**re: Grading & Servicing Plan Review
Proposed Multi-Storey Building
357, 361, 363 Preston Street – Ottawa, Ontario**

file: PG6238-MEMO.02

- ❑ WSP - 357, 361, 363 Preston Street– Drawing No. C001 & C002 - Revision 2 dated August 19, 2022.

C001

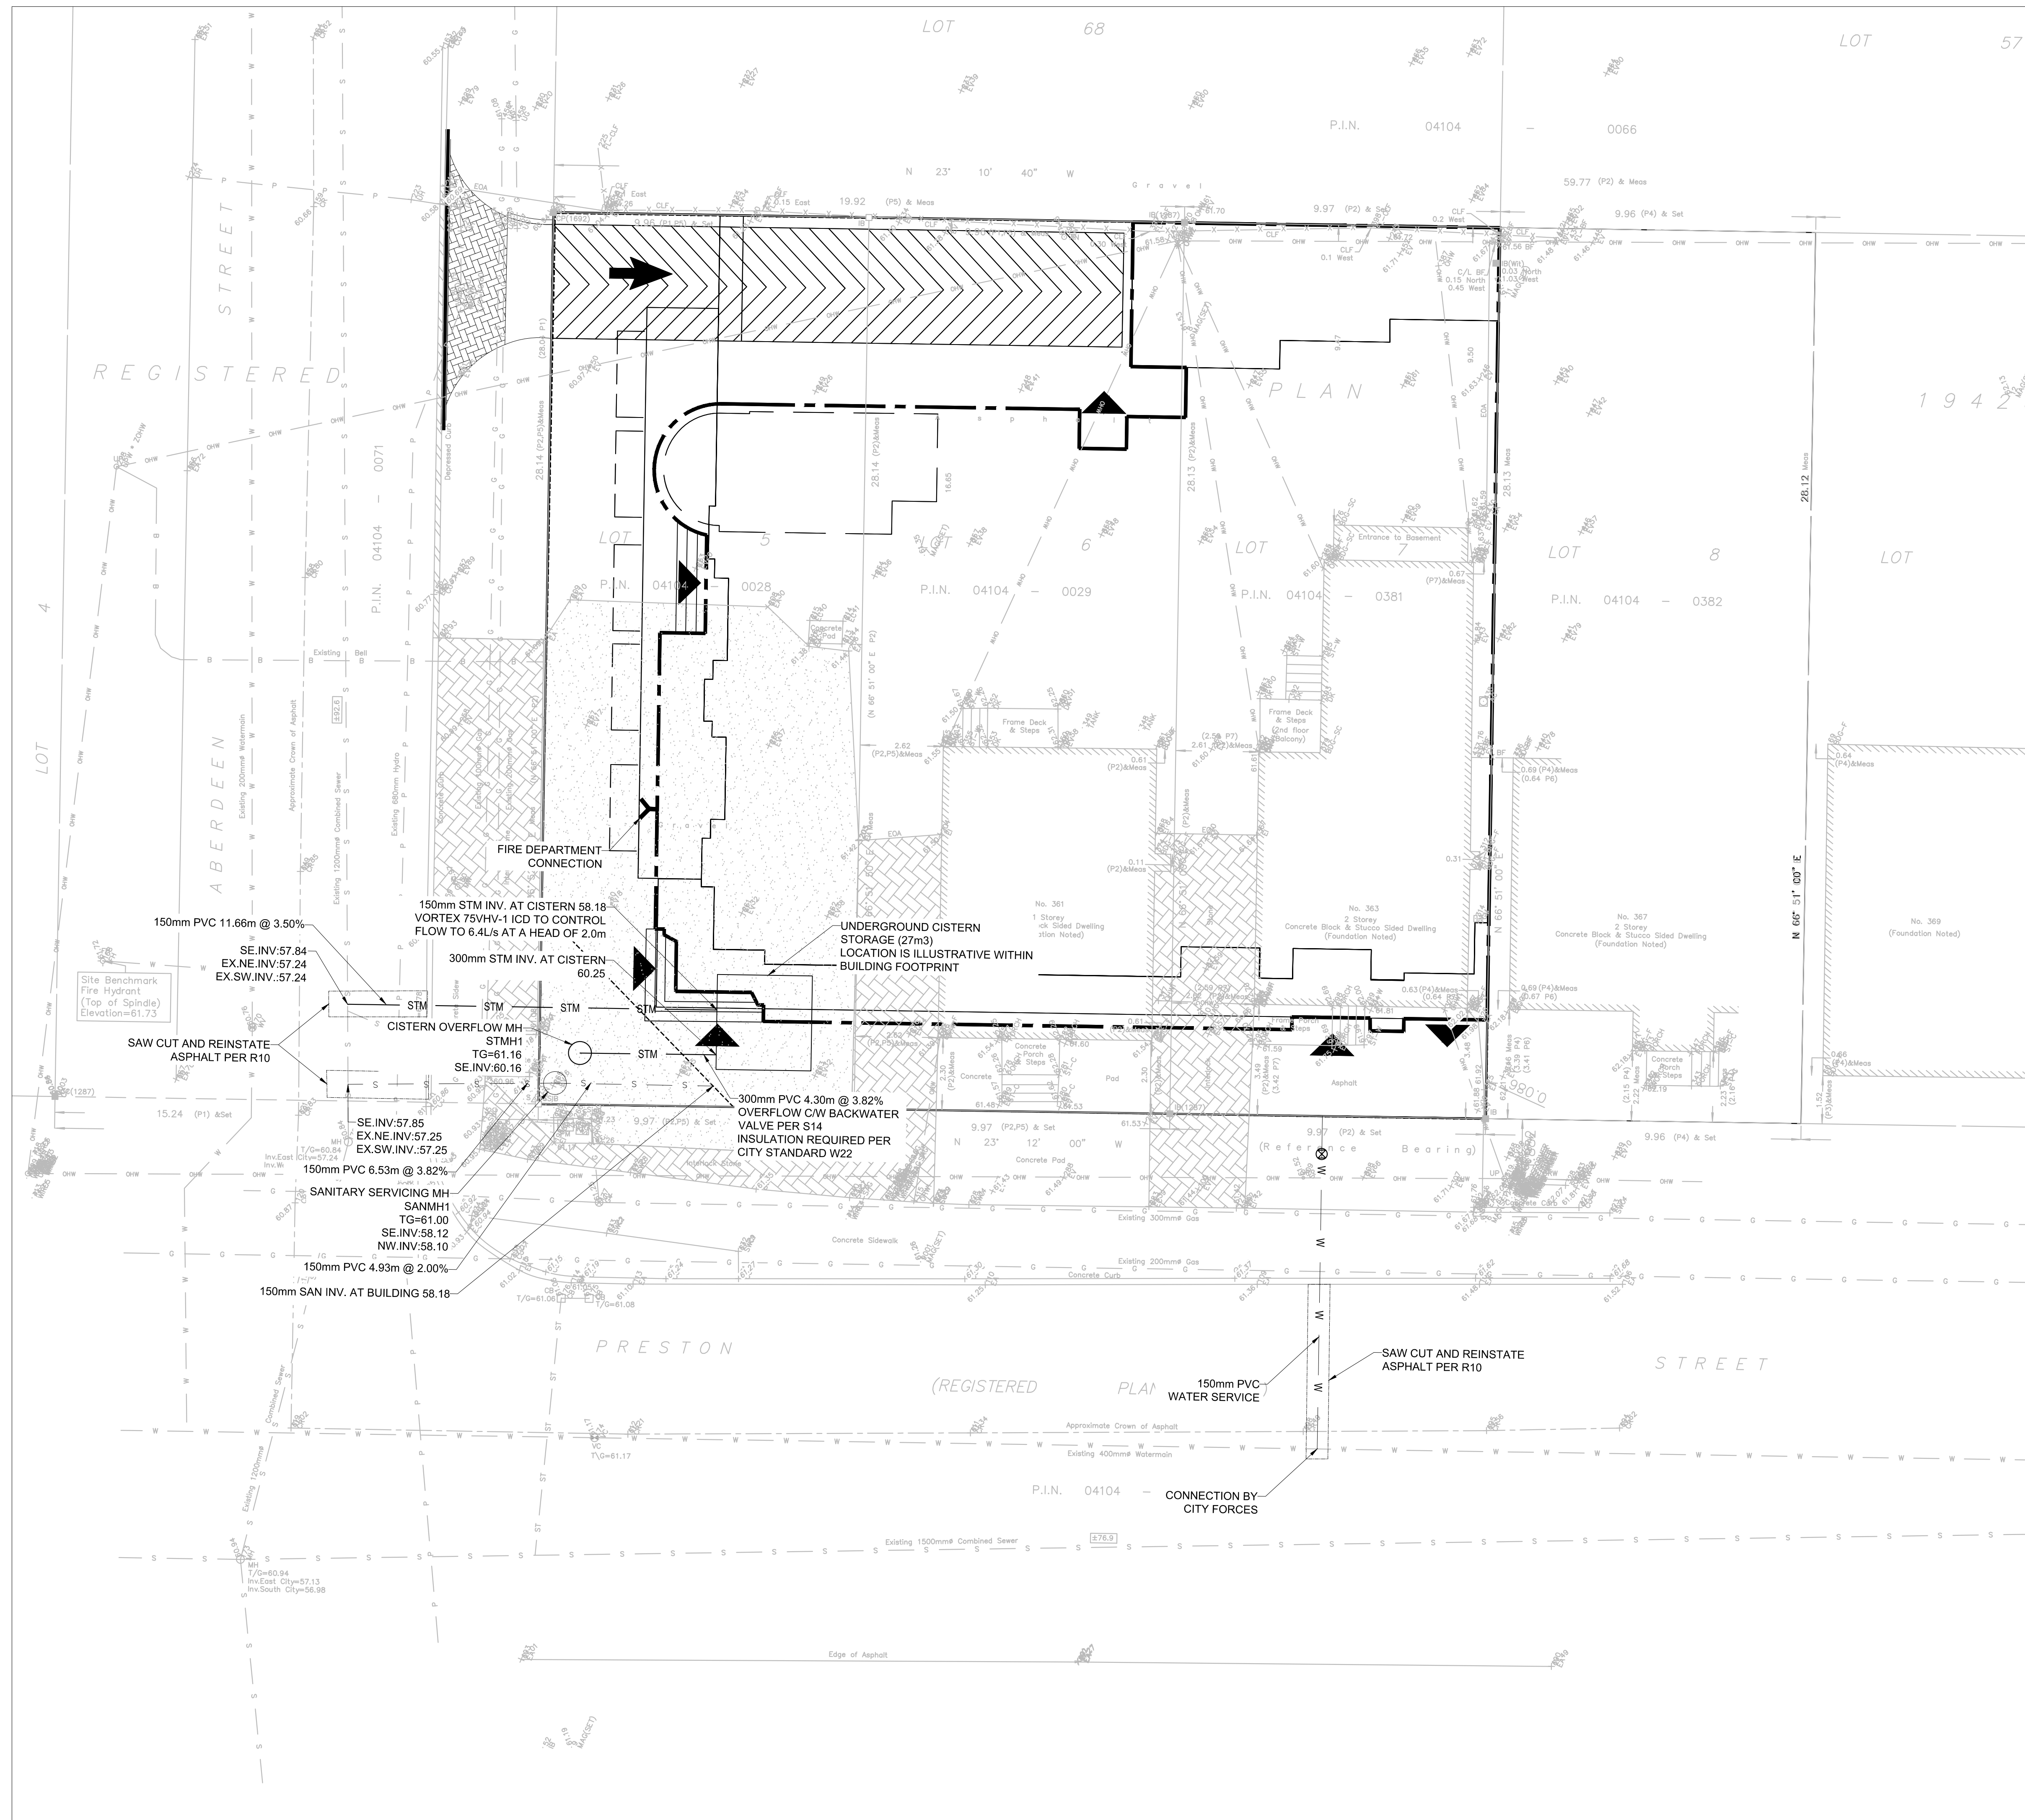
Also, the proposed servicing has sufficient soil cover such that insulation is not required.

C002

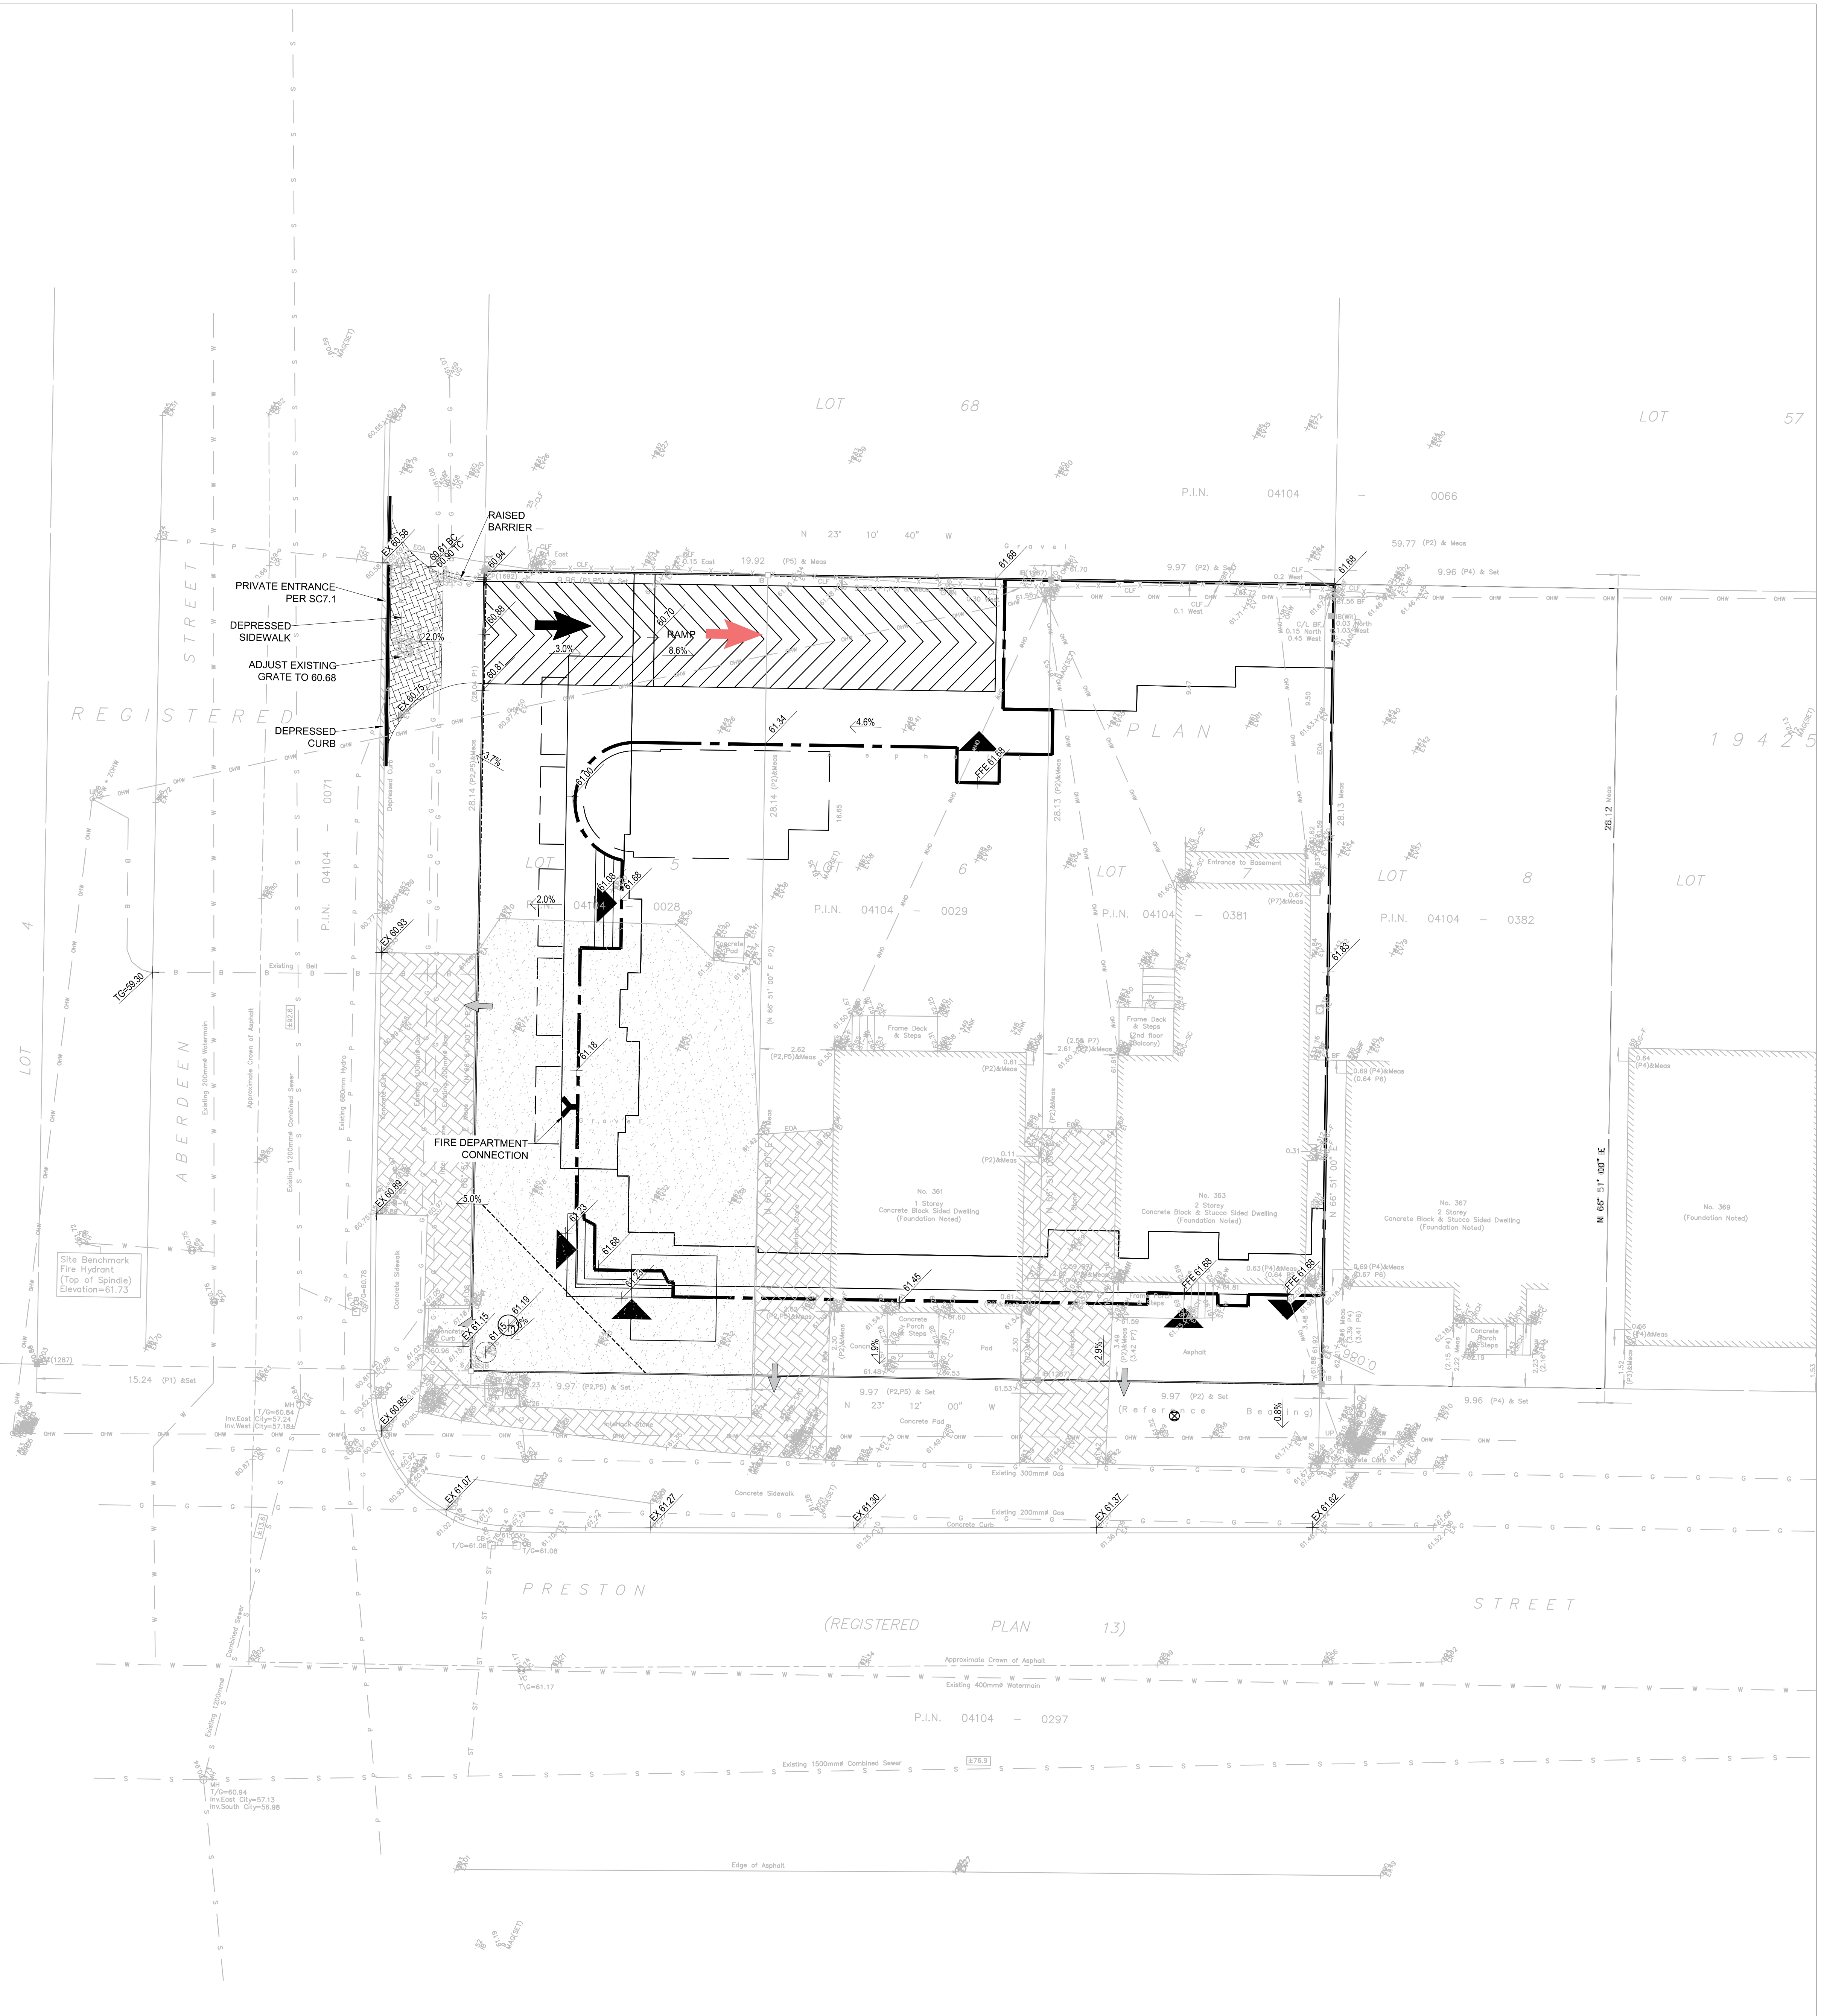
Based on our review of the above-noted drawings and the subsurface conditions present at the subject site, the grading is considered acceptable, from a geotechnical perspective. A silty clay deposit was not encountered during the geotechnical investigation and therefore no permissible grade raise restrictions have been provided for the subject site. Further, tree planting setbacks, based on the 'Tree Planting in Sensitive Marine Clay Soils - 2017 Guideline', are not required.
